April 13, 2017

Subject: Response to City's Comments dated March 14, 2017
27th Street Short Plat
7239 Southeast 27th Street
Mercer Island, Washington 98040
RGI Project No. 2016-120

As requested, The Riley Group, Inc. (RGI) is responding the review comments from the City of Mercer Island, prepared by Robin Proebsting dated March 14, 2017.

7239 SE 27TH STREET SHORT PLAT

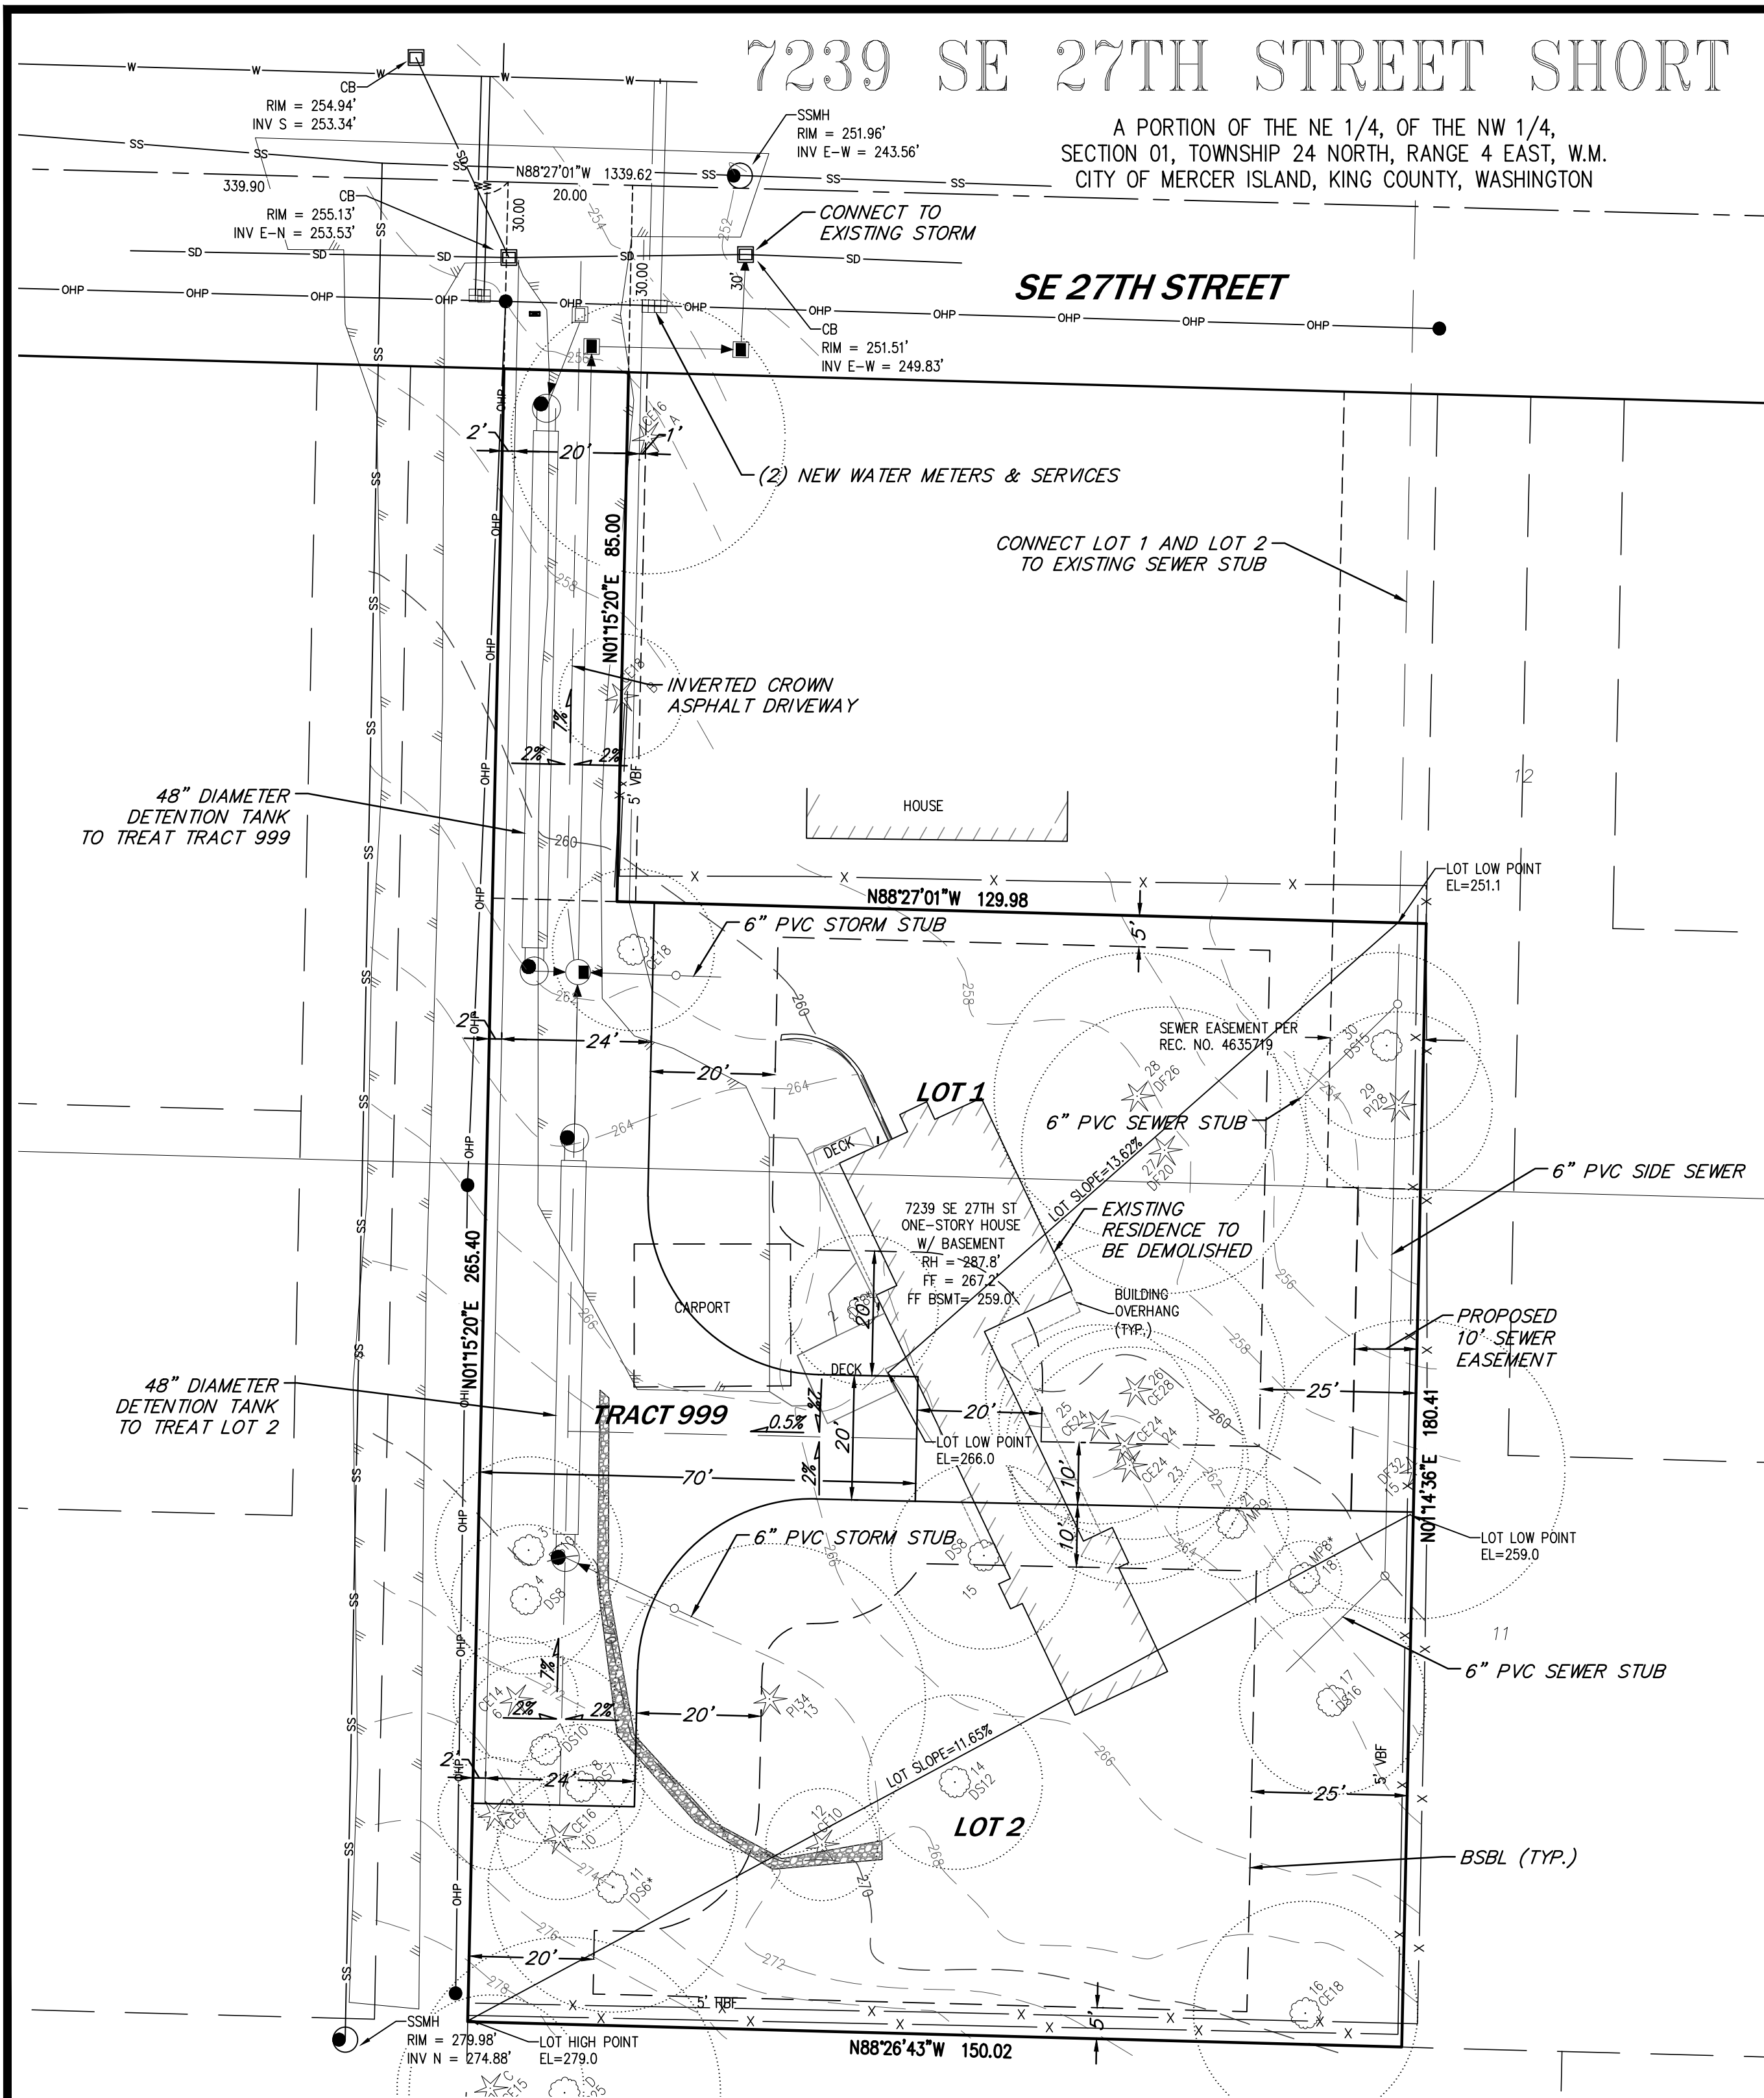
Question 3: *The geotechnical report addendum dated October 24, 2016 describes characteristics of the site and notes that 1) the potential for landslide along the eastern property line does not exist, and 2) most of the site has a moderate erosion hazard. Please verify whether portion of the site meet the definitions of land hazards, erosion hazard areas /or seismic hazard areas as defined in the MICC 19.16 and if so, the portion of the site in which these area are present.*

Only a small portion of the building pad on the south side of Lot 2 exceeds 15 percent slope meet the definition of Erosion Hazard Area. Based on the Web Soil Survey by National Cooperative Soil Survey. The southwest corner of the site is mapped as Arent, Alderwood material, 6 to 15 percent slope (AmC). Runoff is medium and the erosion hazard to moderate to severe.

Answer: RGI reviewed the City of Mercer Island Municipal Codes (MICC 19.16). The review indicates that the site does not meet any of the definitions of Landslide Hazard Areas or Seismic Hazard Areas.

The erosion control measures provided in our referenced report, if incorporated into the project design should be adequate to control erosion on the site. Based on the soils encountered and the slopes on site, the development will not increase the potential of soil erosion on the site or on adjacent sites if the recommended erosion control measures are implemented during construction.
